THE SHOP'S AT MERIDIAN RANCH

FILING NO. 1, LOT 4
LANDSCAPE PLAN
EL PASO COUNTY, COLORADO.
FALCON, COLORADO

FILE NUMBER: PPR18033

DRAWING NO. **2**
LANDSCAPE PLAN

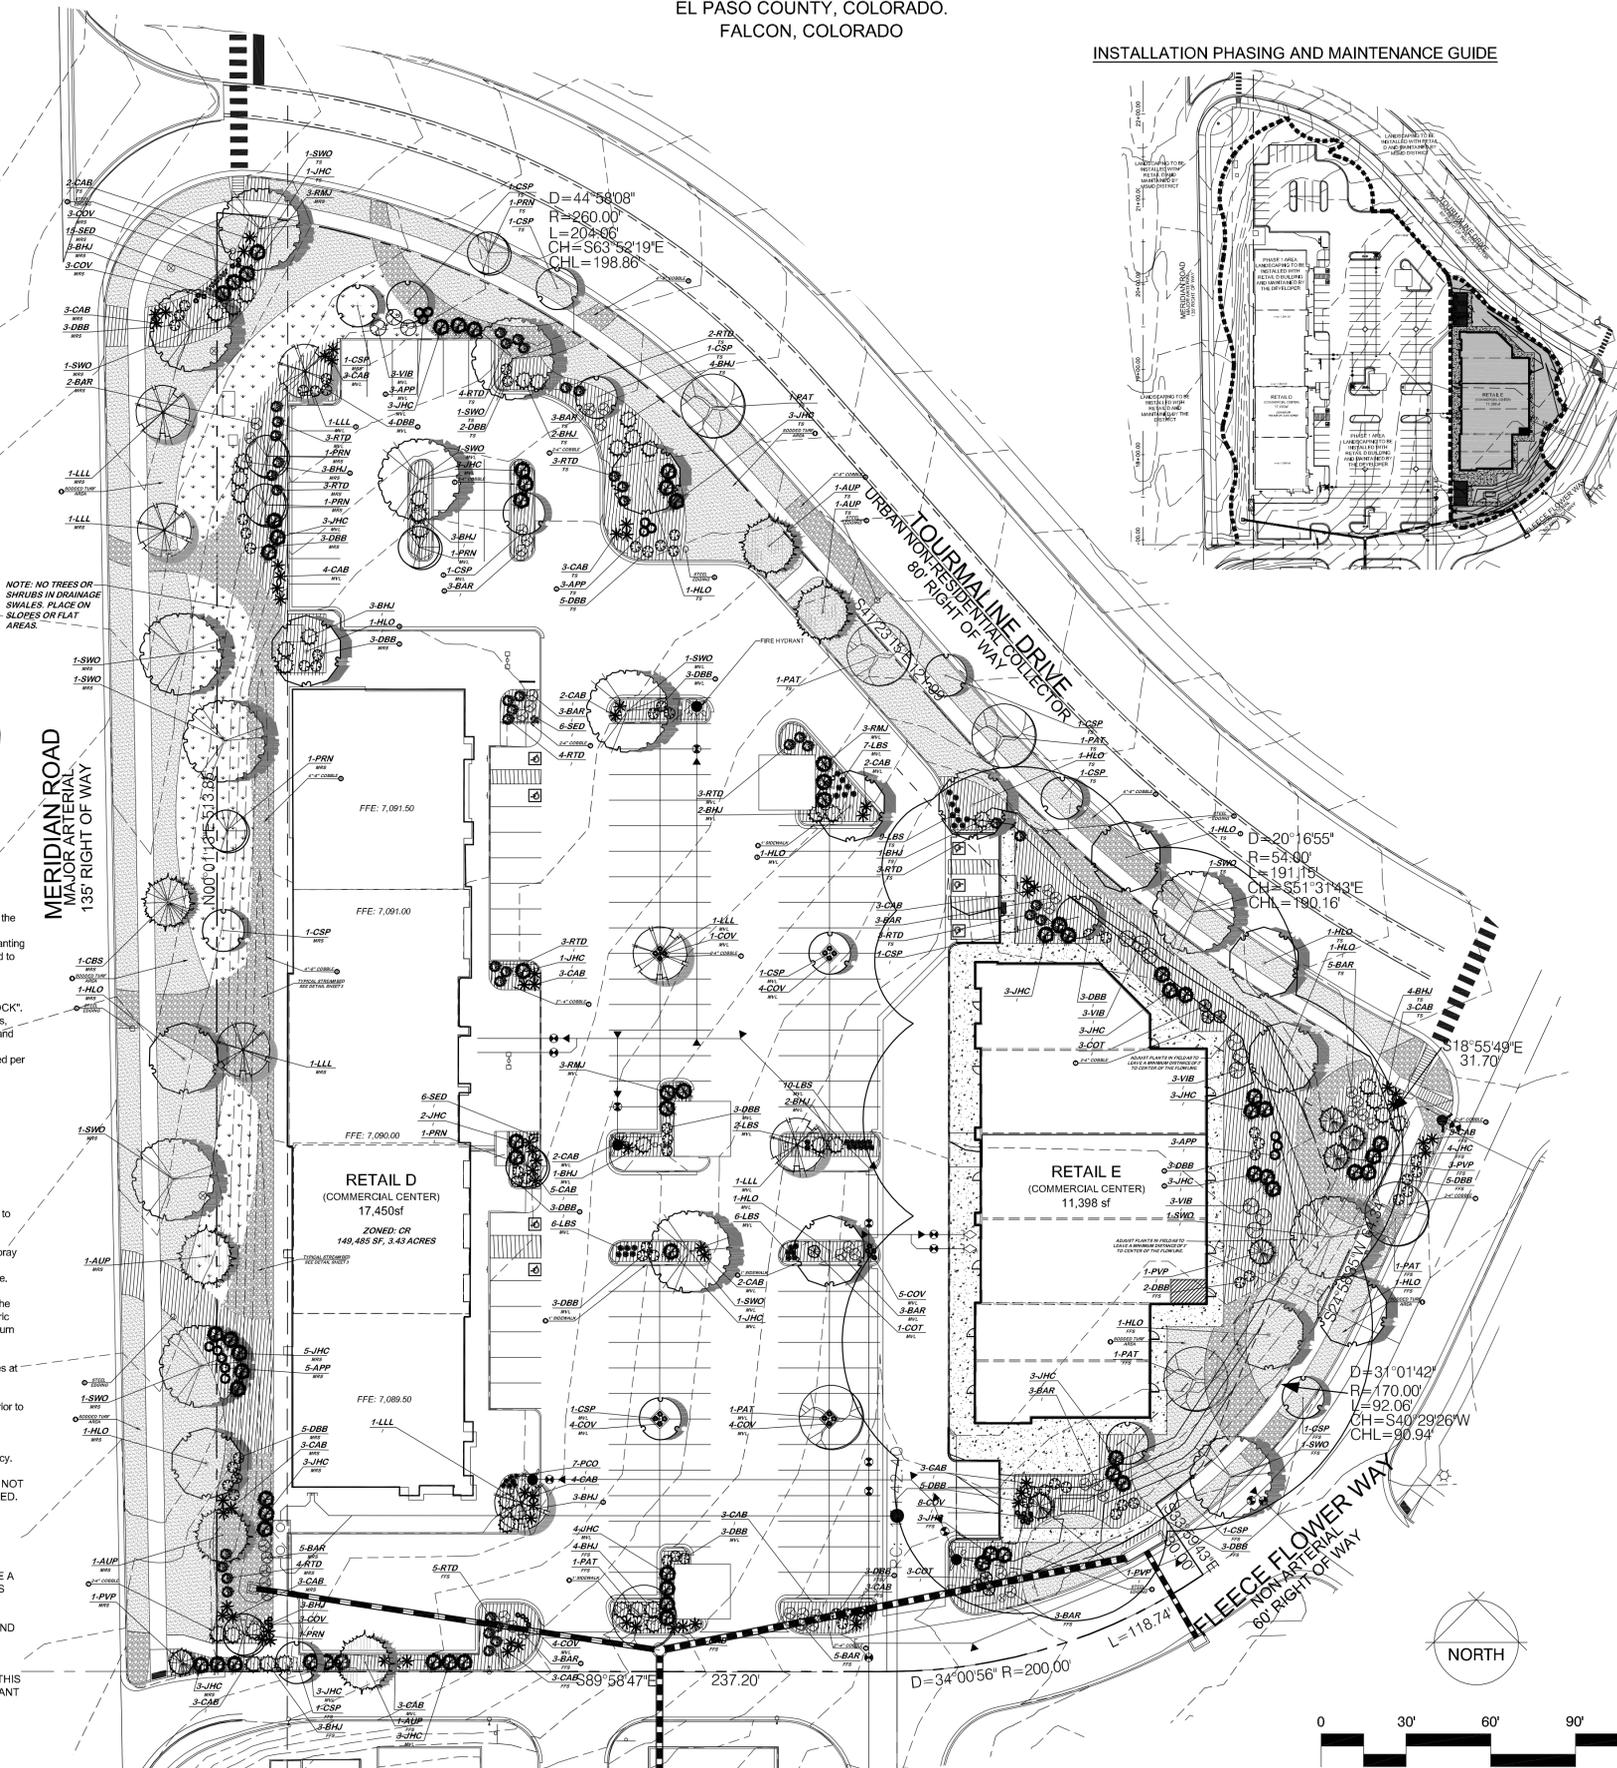
Please provide area calculation table for internal landscaping required and parking lot islands required

Provide justification for not meeting required threshold
